Tel: 01903 737756
Email: planning@arun.gov.uk
www.arun.gov.uk/planning
Please ask for: Ms Ella Summerfield
Email: ella.summerfield@terraquest.co.uk
Telephone: 0121 2341390
Our Ref: CM/21/26/L
Your Ref:
Date: 24th August 2026

Listed Building Consent for Alterations, Extension or Demolition of a Listed Building

Development: Replacement of existing windows (7 no. in total) plus 1 no. exterior door with identical style.

Location: Kents Farm House Brookpit Lane Climping BN17 5QU

ELEVATION C-C

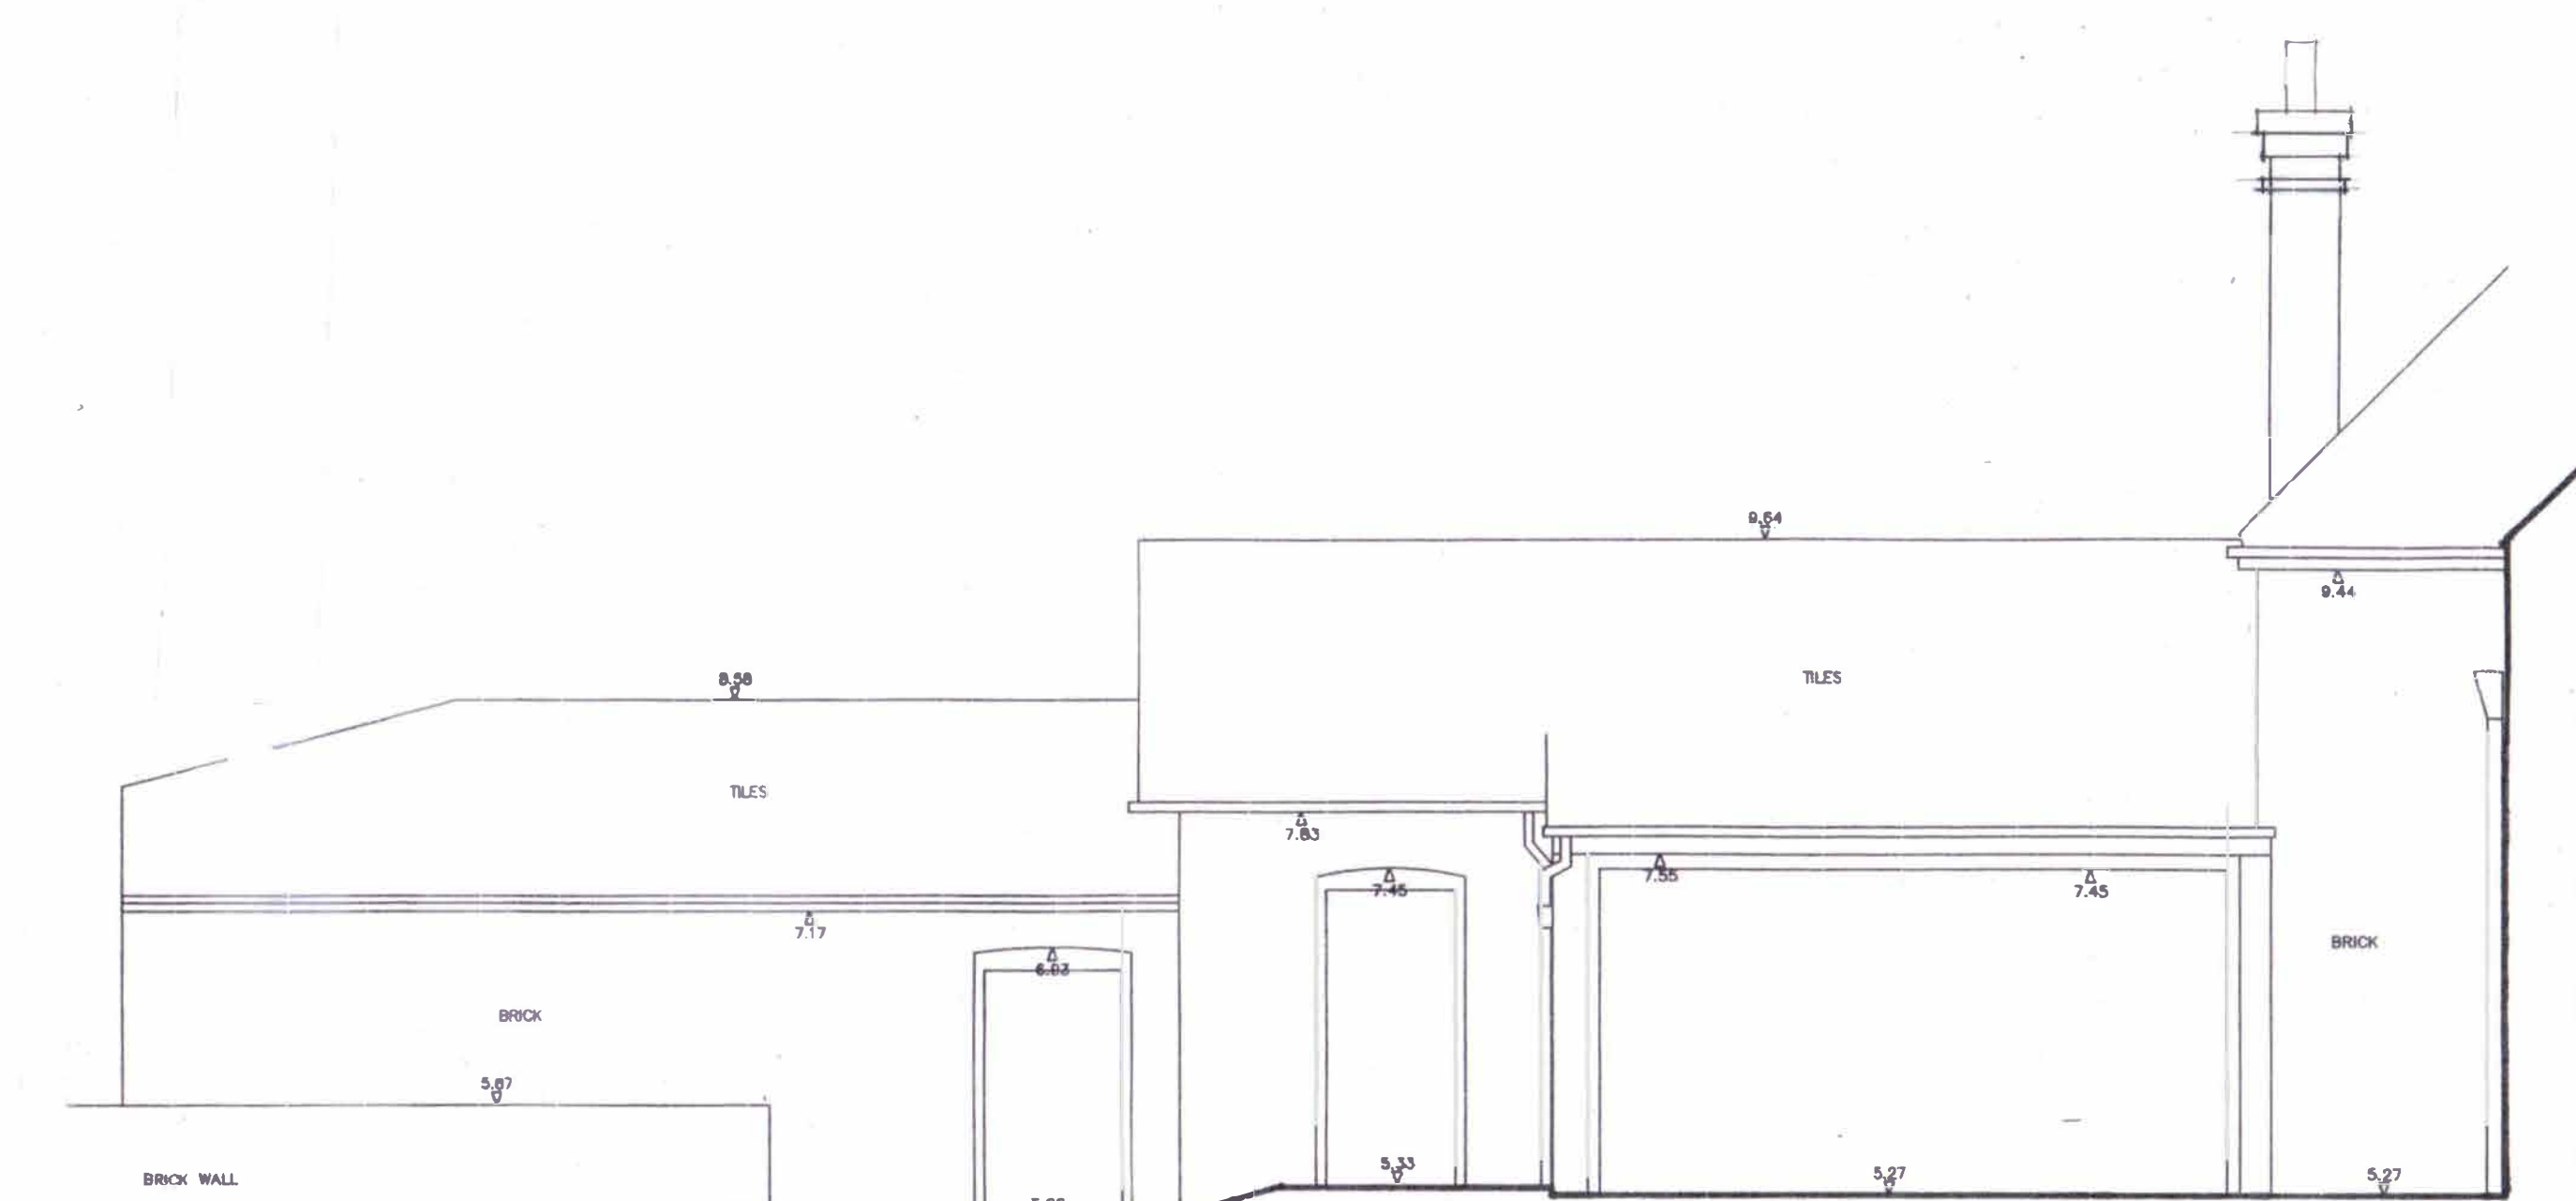
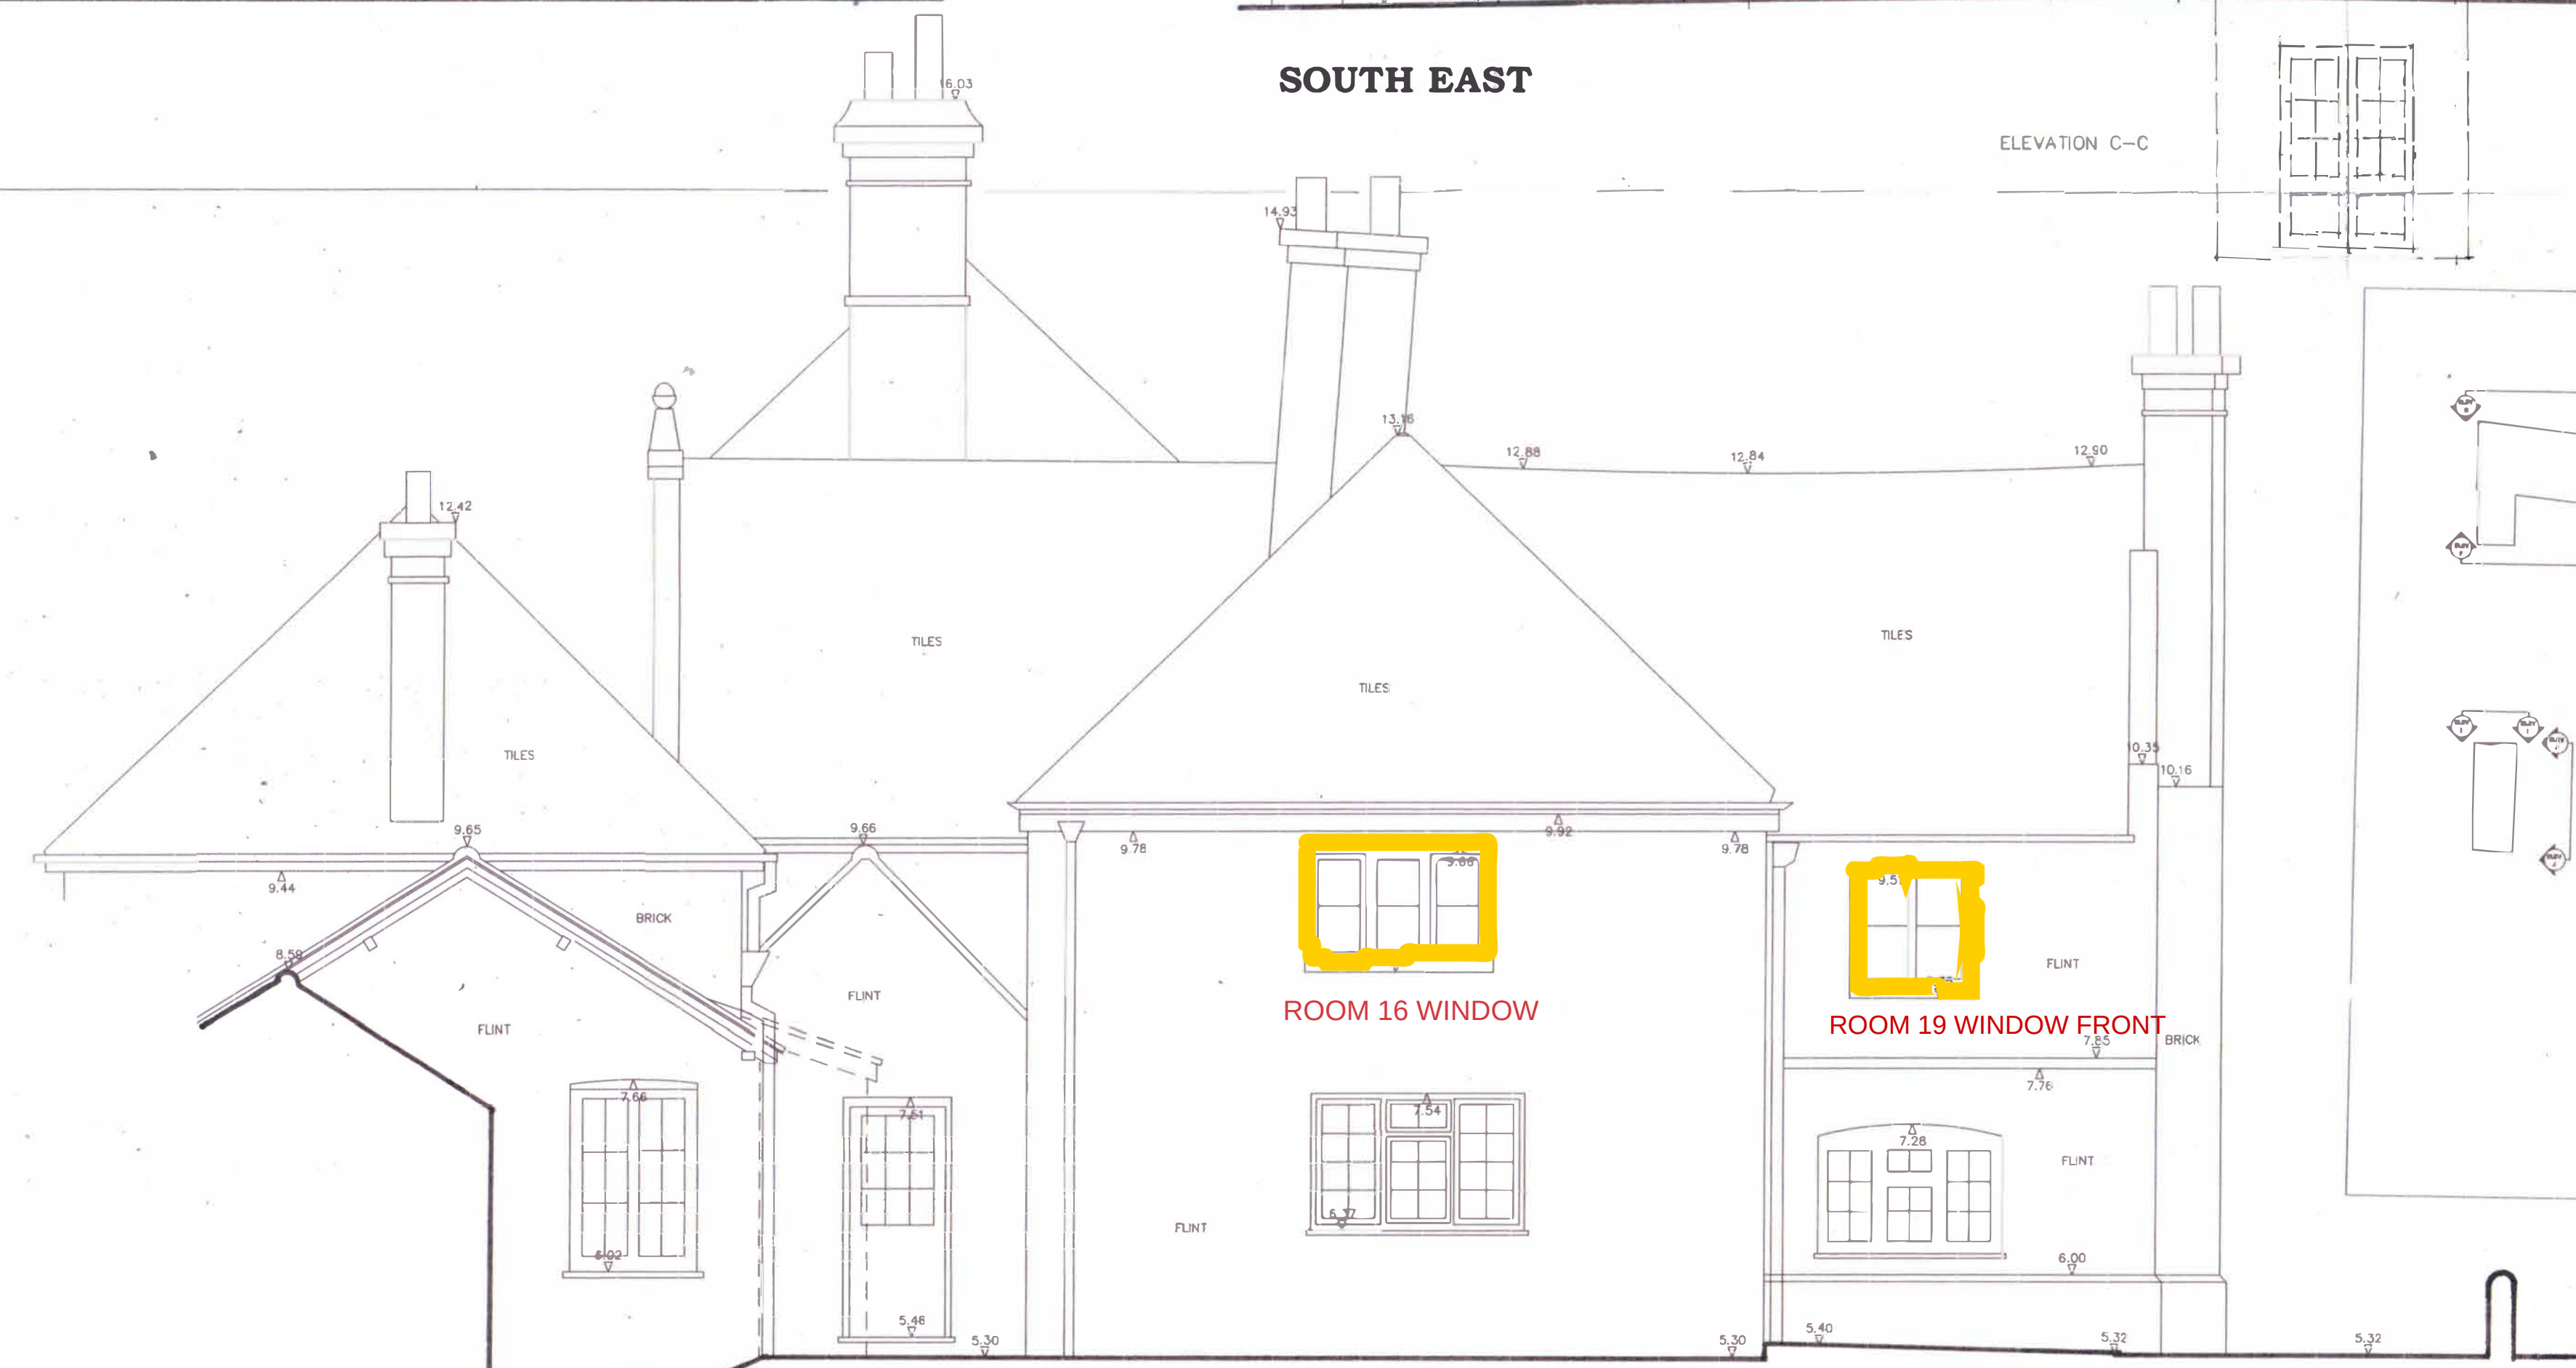
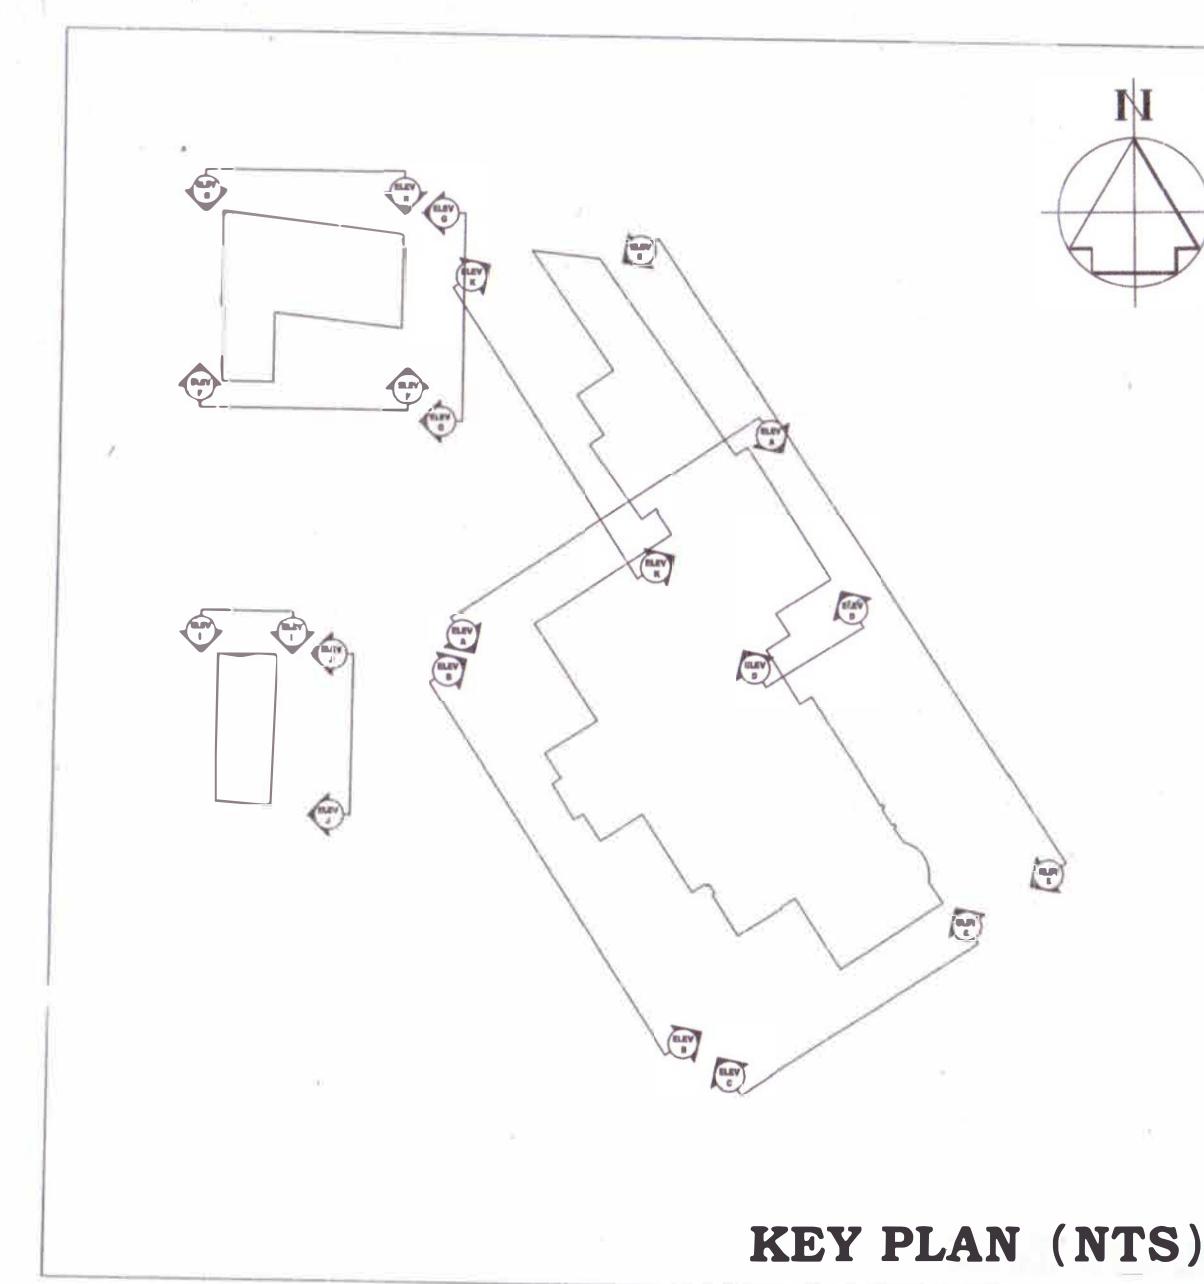
The proposed elevation plan scale bar appears to be inaccurate to the provided scale, please review.
